ENG-PUDSP21002-R2-PUDSP.pdf Markup Summary

PUD TRACT MAP AND DETAILS

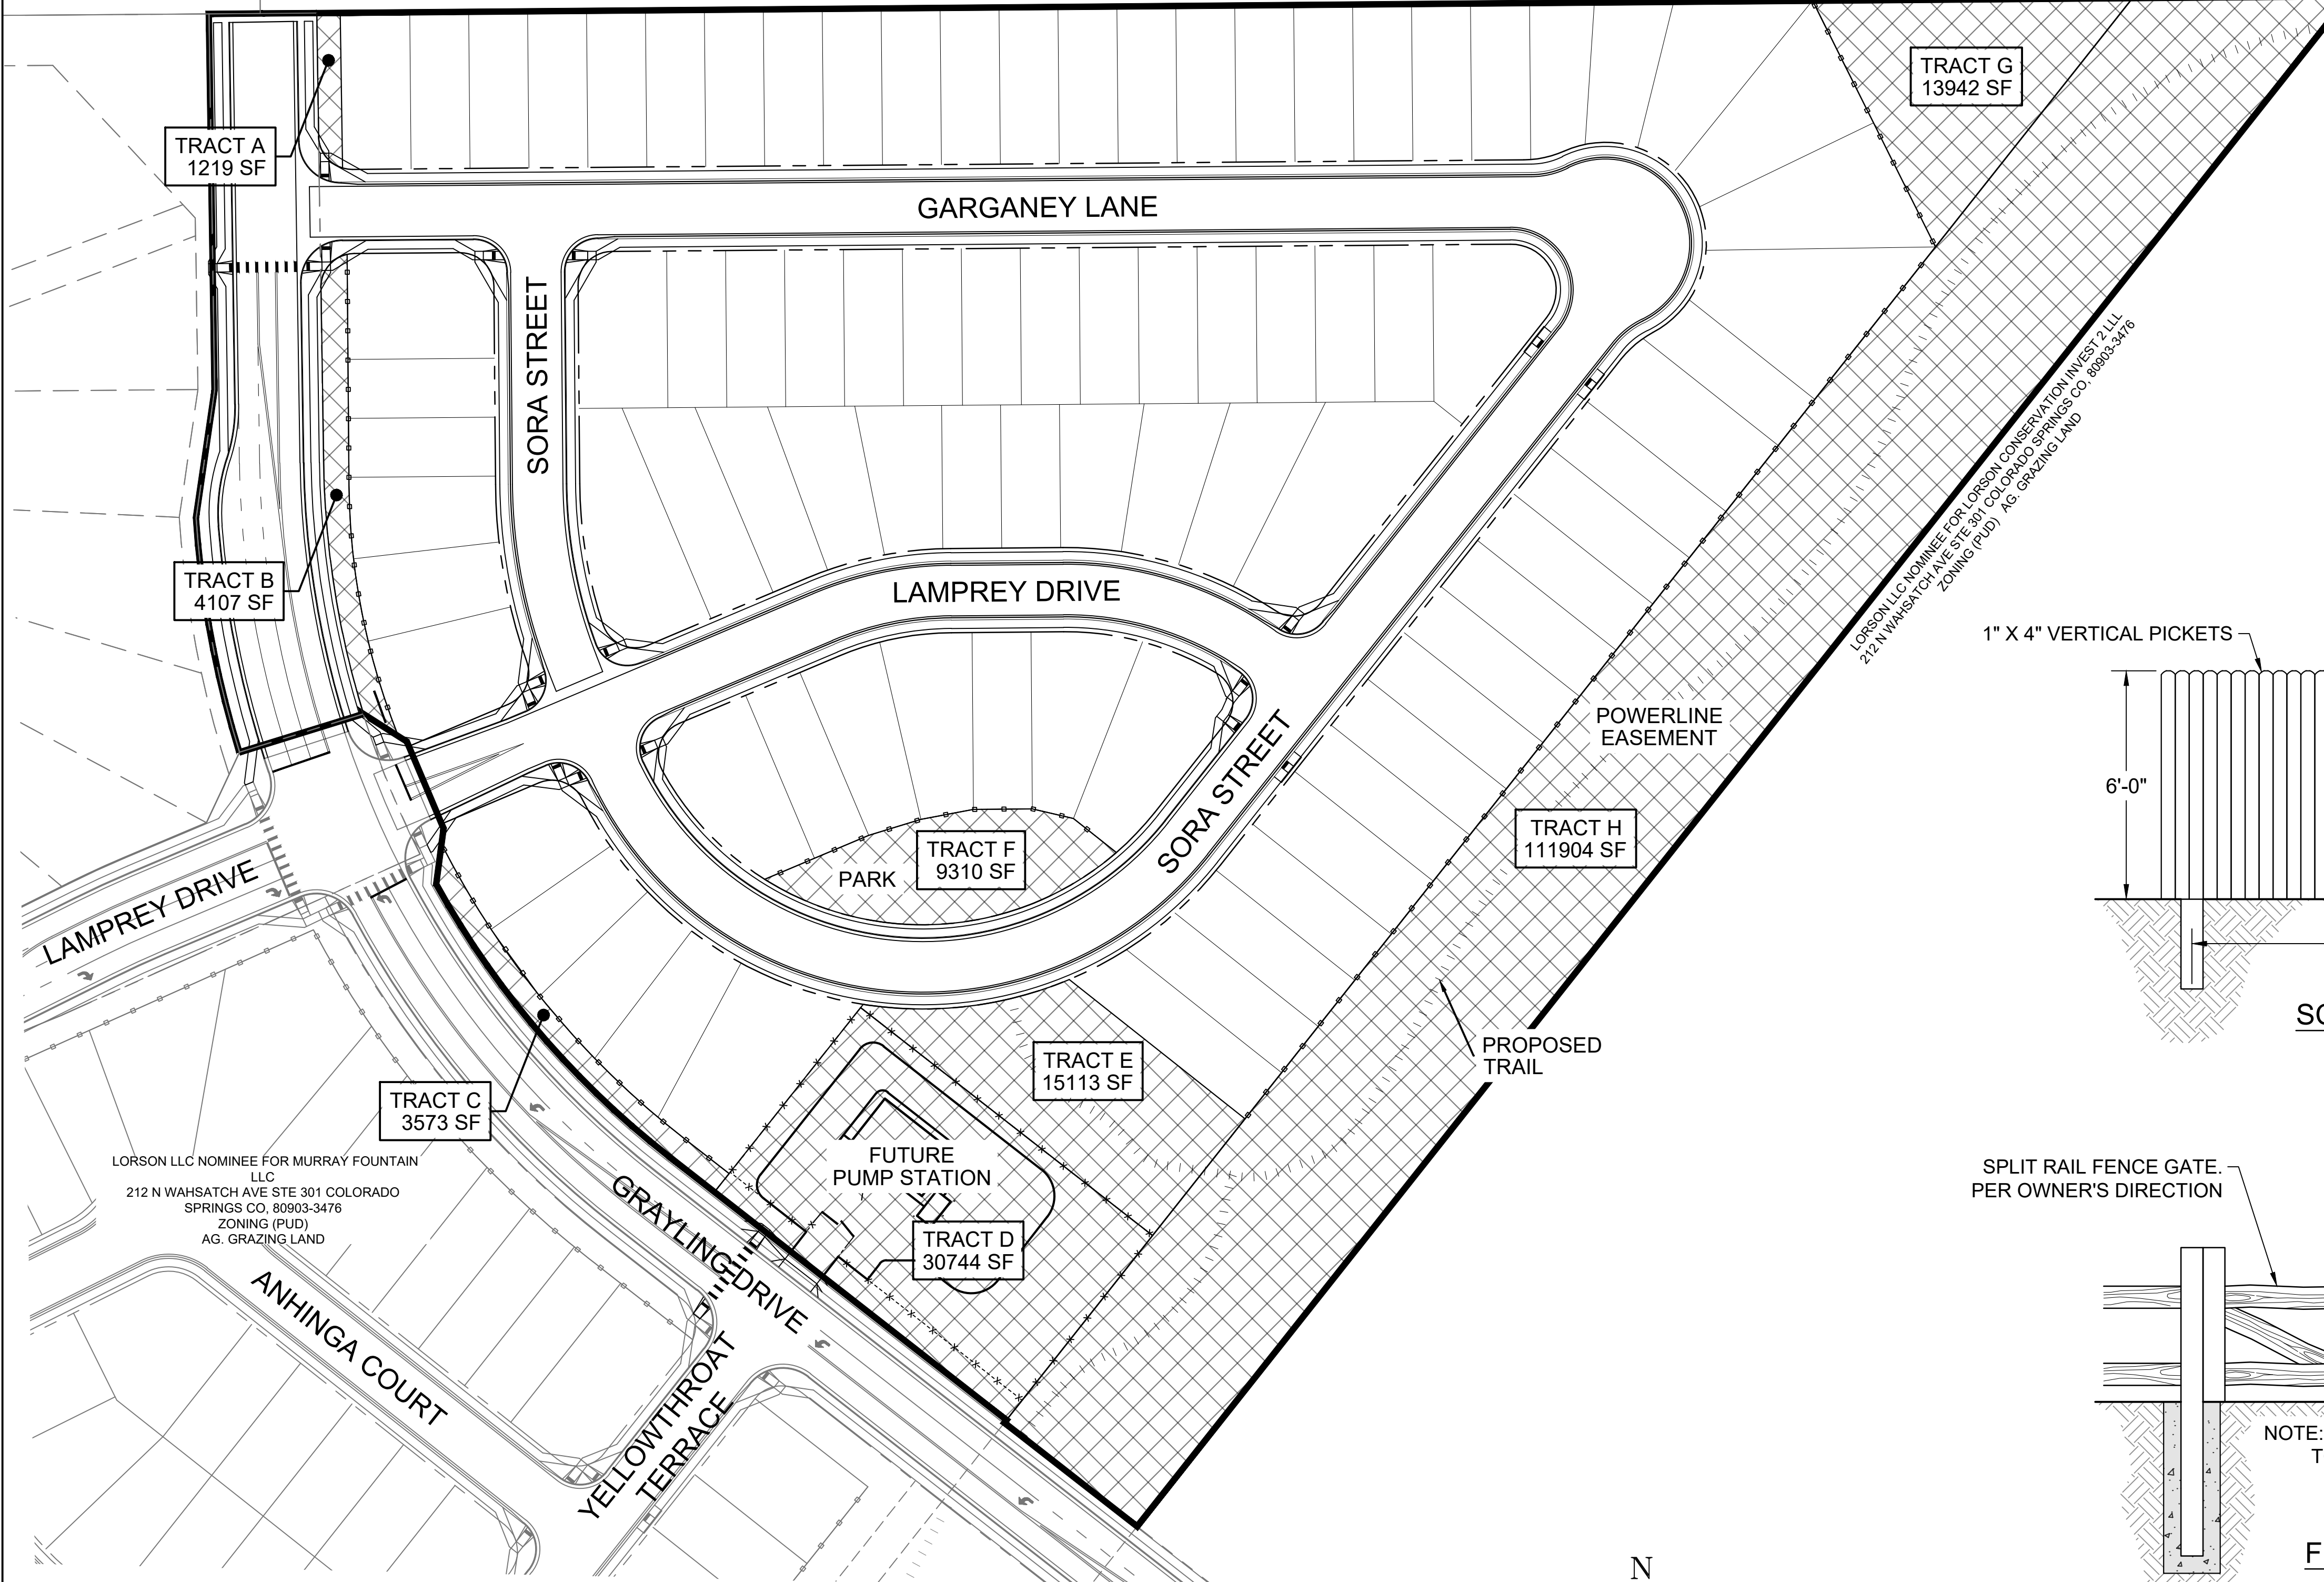
Subject: Callout
Page Index: 1
Date: 7/29/2021 3:38:29 PM
Author: dsdparsons
Color: ■
Layer:
Space:

State who will own and maintain walls to hold grading on lots throughout site (landscape walls) Rich Schindler said the DISTRICT IS NOT maintaining these. State size from 1'-4' foot is allowed at the individual site plan within setbacks.... Walls greater than 4-feet up to 7' feet are allowed in setbacks but MUST be engineered. (is there a design standard for these? SHoW)

Subject: Text Box
Page Index: 1
Date: 7/29/2021 3:43:11 PM
Author: dsdparsons
Color: ■
Layer:
Space:

" Low to very high swell potential in the underlying soils and bedrock require mitigation. Provided all RMG's recommendations are strictly adhered to, CGS has no objection to the planned development. Prior to residential construction lot-specific subsurface soil investigations are required for site-specific foundation design and other engineering aspects related to development."

Subject: Callout
Page Index: 1
Date: 7/29/2021 3:43:20 PM
Author: dsdparsons
Color: ■
Layer:
Space:

modify note to incorporate CGS comments

Subject: Callout
Page Index: 1
Date: 8/5/2021 2:48:42 PM
Author: dsdrice
Color: ■
Layer:
Space:

Fences shall not block sight distance triangles.
